CITY OF ALBUQUERQUE

Planning Department
Alan Varela, Director

September 2, 2022

Re: Broadway Cultivation Facility
1340 Broadway Blvd. NE
Traffic Circulation Layout
Architect's Stamp 06-15-22 (J14-D202)

- ### SITE PLAN KEY NOTES
- NEW TRASH ENCLOSURE PER CITY OF ABQ SOLID WASTE SPEC. SEE DETAIL D3/AS-101. SOLID WASTE SHALL HAVE ACCESS AT ALL TIMES TO DUMPSTER. NO FENCE OR GATE ACCESS REQUIRED. STANDARD REFUSE ONLY, NO PRODUCT OR HAZARDOUS MATERIAL WILL BE DISPOSED OF IN CITY DUMPSTER.

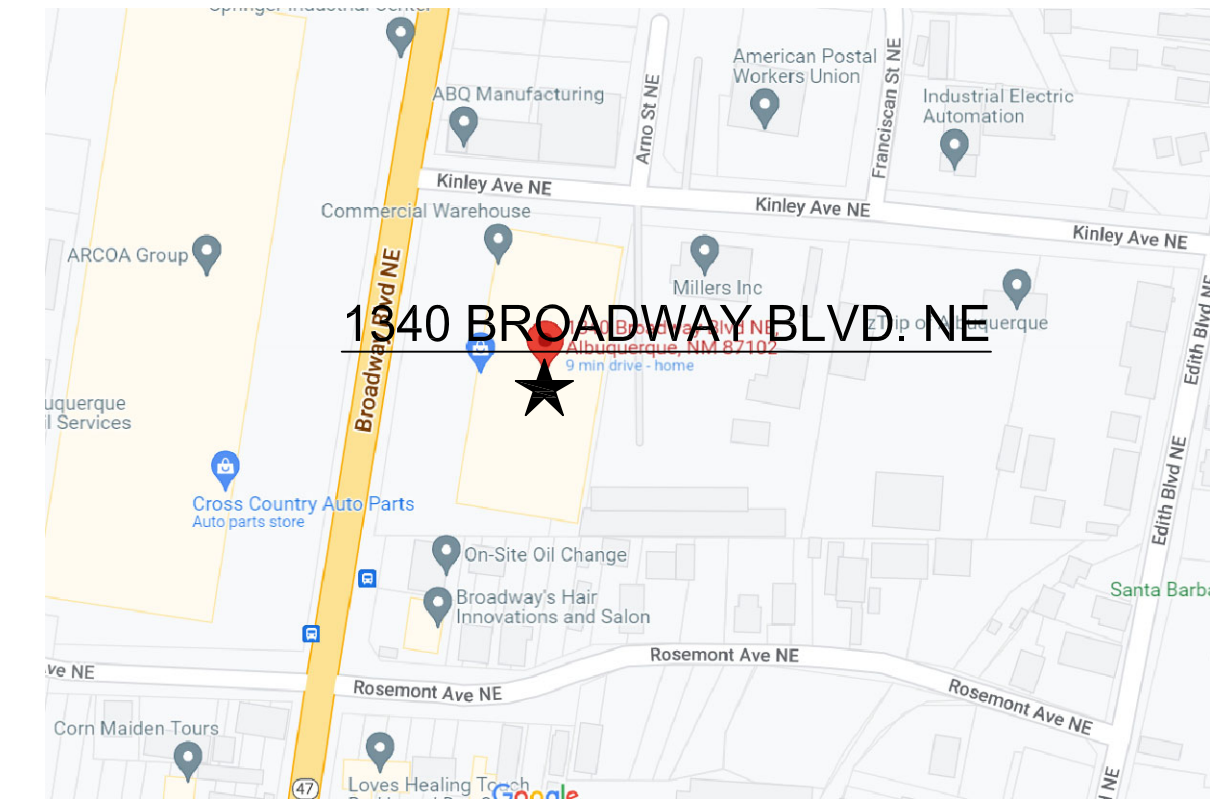
1. Please see attached Minimum Distance from Commercial Site Access Points to the Intersection. Also, note that Broadway Blvd. is classified as Principal Arterial, and Kinley Ave. classified as Local St.
2. Curb Return Access design need to provided.
3. Maximum access width for arterial, collector, and local streets are as follows:

4. Please list the width and length for all existing and proposed parking spaces. Some dimensions are not shown.
5. The minimum parking stall dimensions are:

6. ADA Ramp at the corner of Broadway Blvd. and Kinley Ave. need to be updated to current COA standard.
7. ADA curb ramps must be updated to current standards and have truncated domes installed.

8. Motorcycle parking spaces shall be designated by its own conspicuously posted upright sign, either free-standing or wall mounted per the zoning code. Please provide signs details.

9. The pavement marking "MC" should be shown in the opposite direction for motorcycles entering the parking space.
10. All bicycle racks shall be designed according to the following guidelines:

11. Bicycle racks shall be sturdy and anchored to a concrete pad.
12. A 1-foot clear zone around the bicycle parking stall shall be provided.
13. Bicycle parking spaces shall be at least 6 feet long and 2 feet wide.

14. Per the IDO, a 6 ft. wide ADA accessible pedestrian pathway is required from the public sidewalk to the building entrances. Please clearly show this pathway and provide details.

15. Per DPM, a 6 ft. wide ADA accessible pedestrian pathway is required from the ADA parking stall access aisles to the building entrances. Please clearly show this pathway and provide details.

17. Parking areas shall have barriers to prevent vehicles from extending over public sidewalk, public right-of-way, or abutting lots. Provide details for the barriers curb.

19. Please provide a sight distance exhibit
20. Show the clear Intersection sight distance and add the following note to the plan:
"Landscaping and signage will not interfere with clear sight requirements. Therefore,

signs, walls, trees, and shrubbery between 3 and 8 feet tall (as measured from the gutter pan) will not be acceptable in the clear sight triangle. See attached

21. Please specify the City Standard Drawing Number when applicable.
22. Unused curb cuts must be replaced with sidewalk and curb & gutter. A build note must be provided referring to the appropriate City Standard drawing.
23. Add a note stating "All broken or cracked sidewalk must be replaced with sidewalk and curb & gutter." A build note must be provided referring to the appropriate City Standard drawing.
24. Please provide a letter of response for all comments given.
25. Traffic Studies: See the Traffic Impact Study (TIS) thresholds. In general, a minimum combination of 100 vehicles entering and exiting in the peak hour warrants a Traffic Impact Study. Visit with Traffic Engineer for determination, and fill out a TIS Form that states whether one is warranted. In some cases, a trip generation may be requested for determination (**Contact Matt Grush: mgrush@cabq.gov**).
